Response re: HVO North Open Cut Coal Continuation Project (SSD-11826681)

HVO NORTH OPEN CUT COAL CONTINUATION PROJECT (SSD-11826681)

1. The proponent has not provided sufficient information such that private landholders can understand the scale and nature of the adverse impacts on their properties

Figure 0: Private Land Impacts - Overview

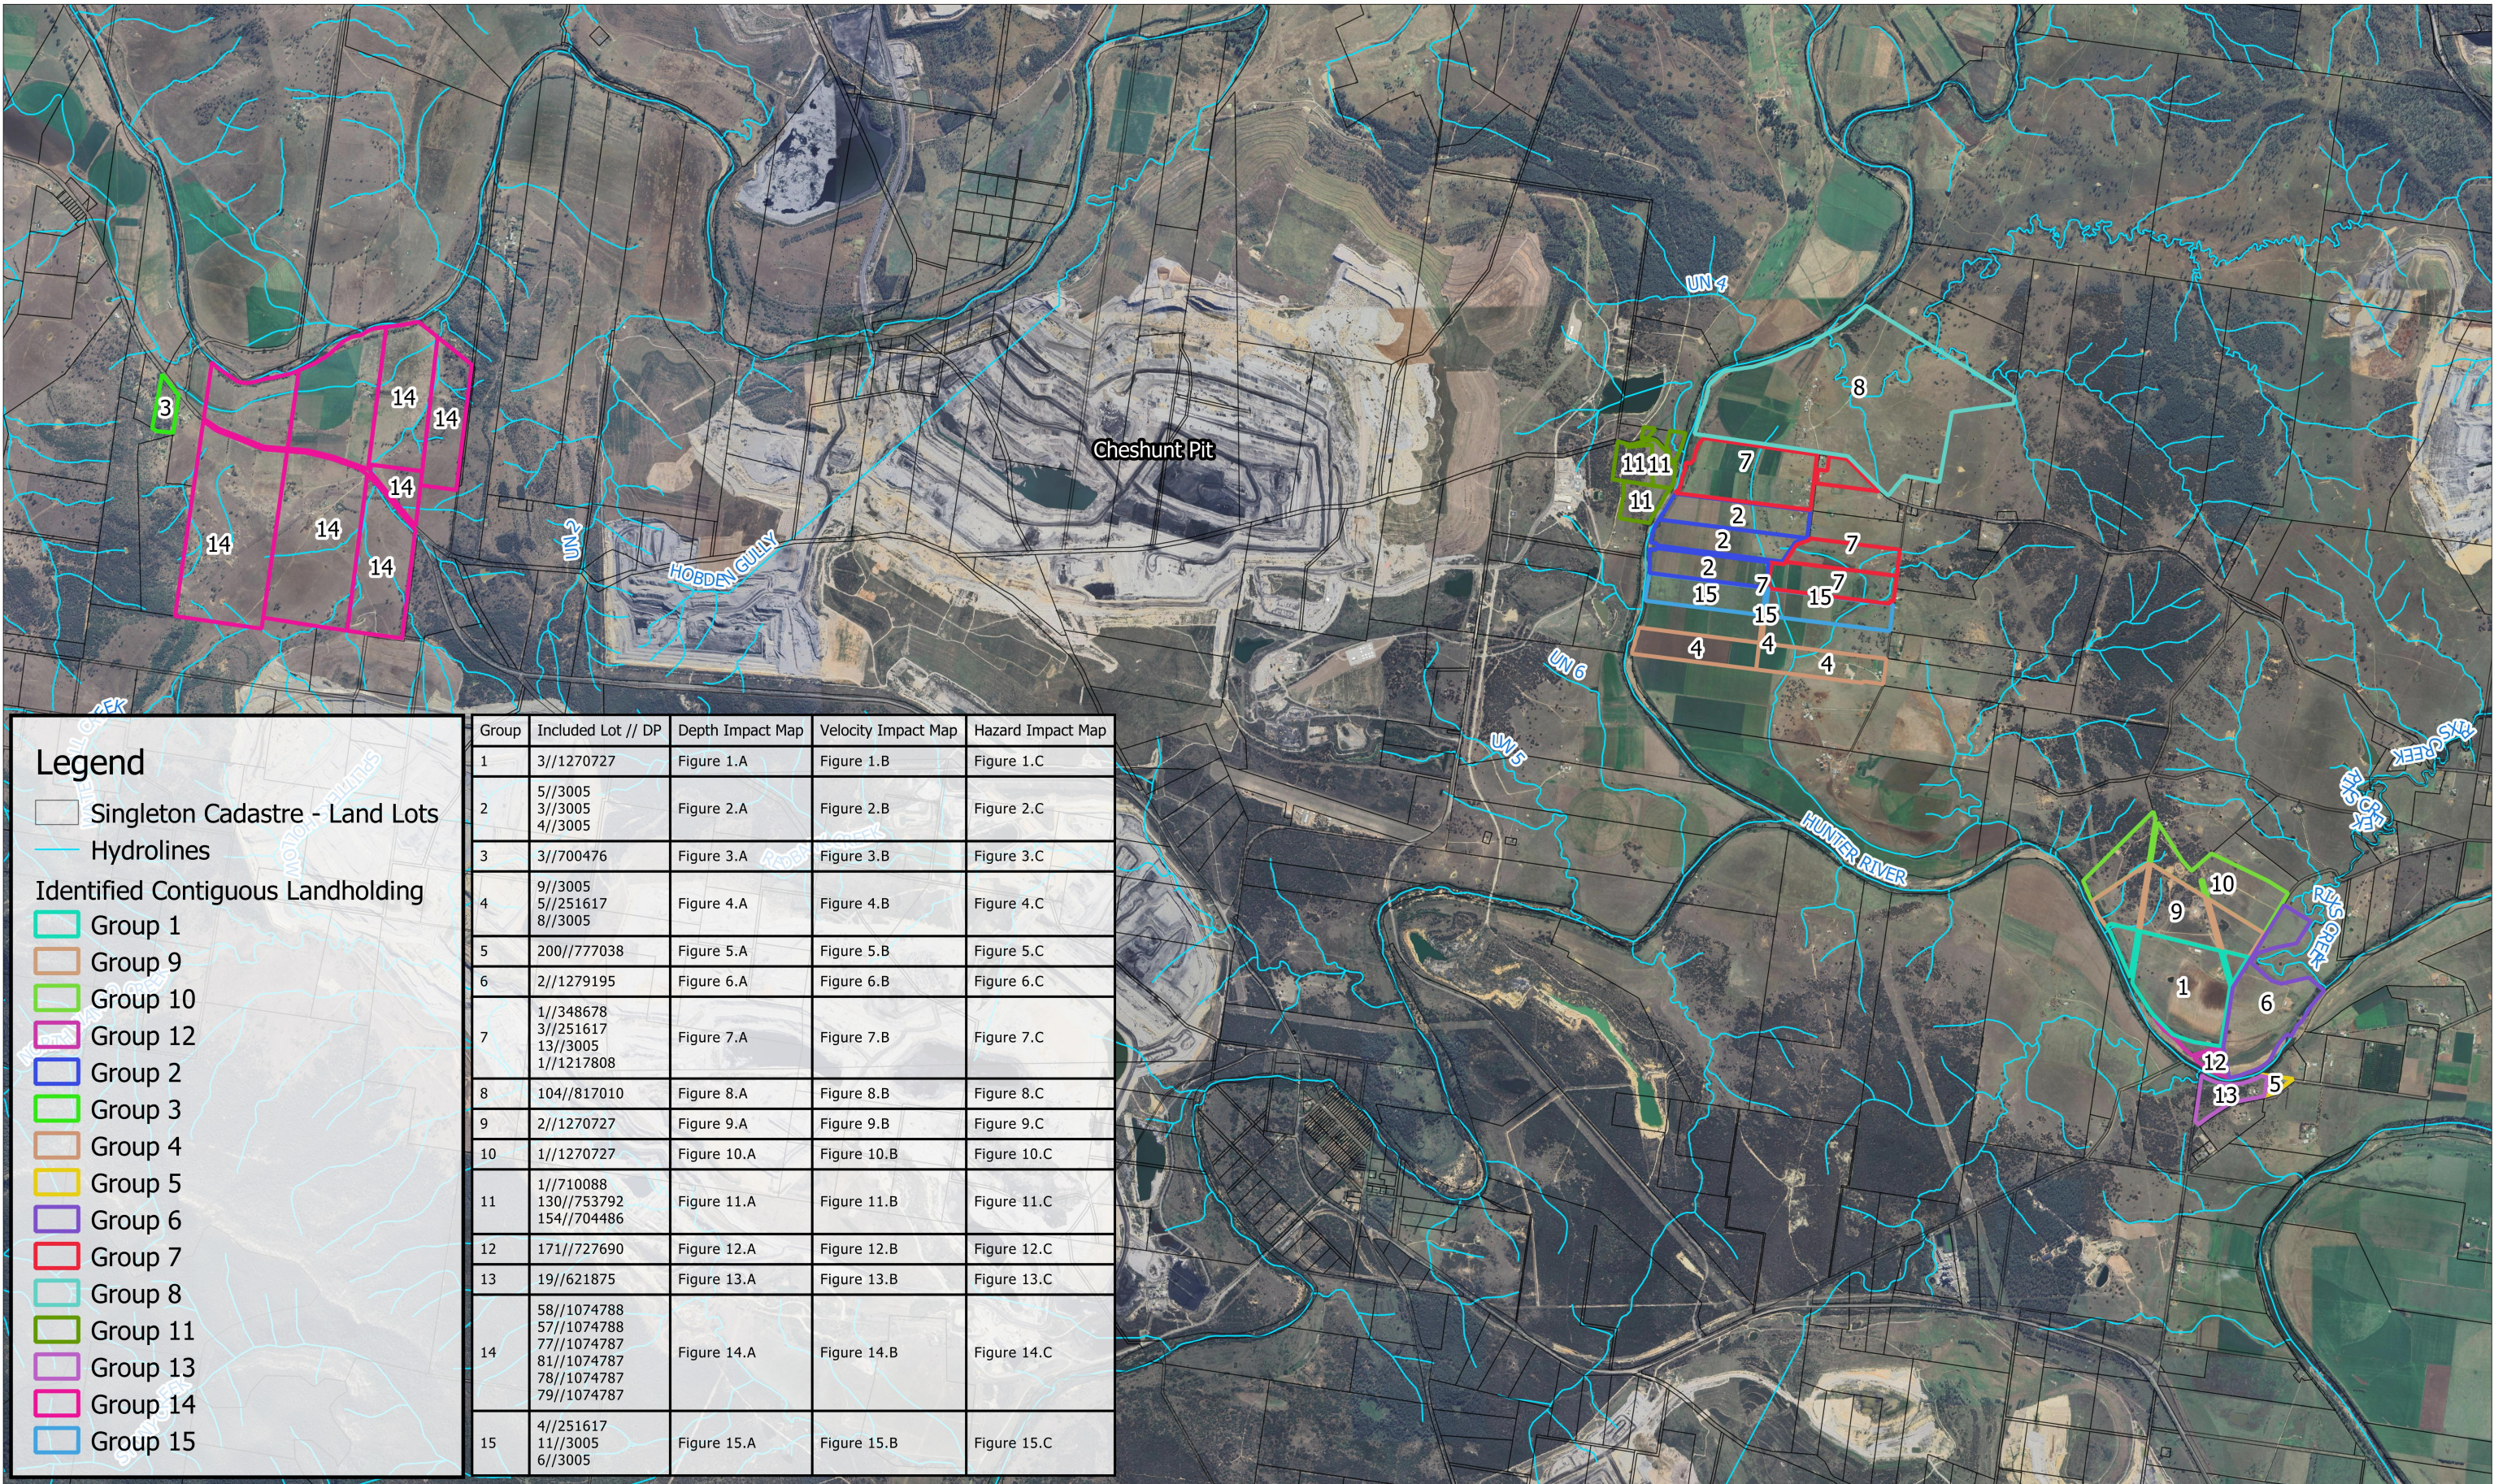
The flood assessment, prepared by Engeny Water Management 2022, identifies that 31 properties, not owned by JV partners, will have adverse flood affluxes in the range of 20-50mm. However, insufficient information has been provided for impacted landholders to know they are impacted or to understand the nature of the impacts.

Produce mapping at an appropriate scale and resolution such that each landholder can clearly understand the estimated increase in flood levels, velocities and hazard as well as time of inundation.
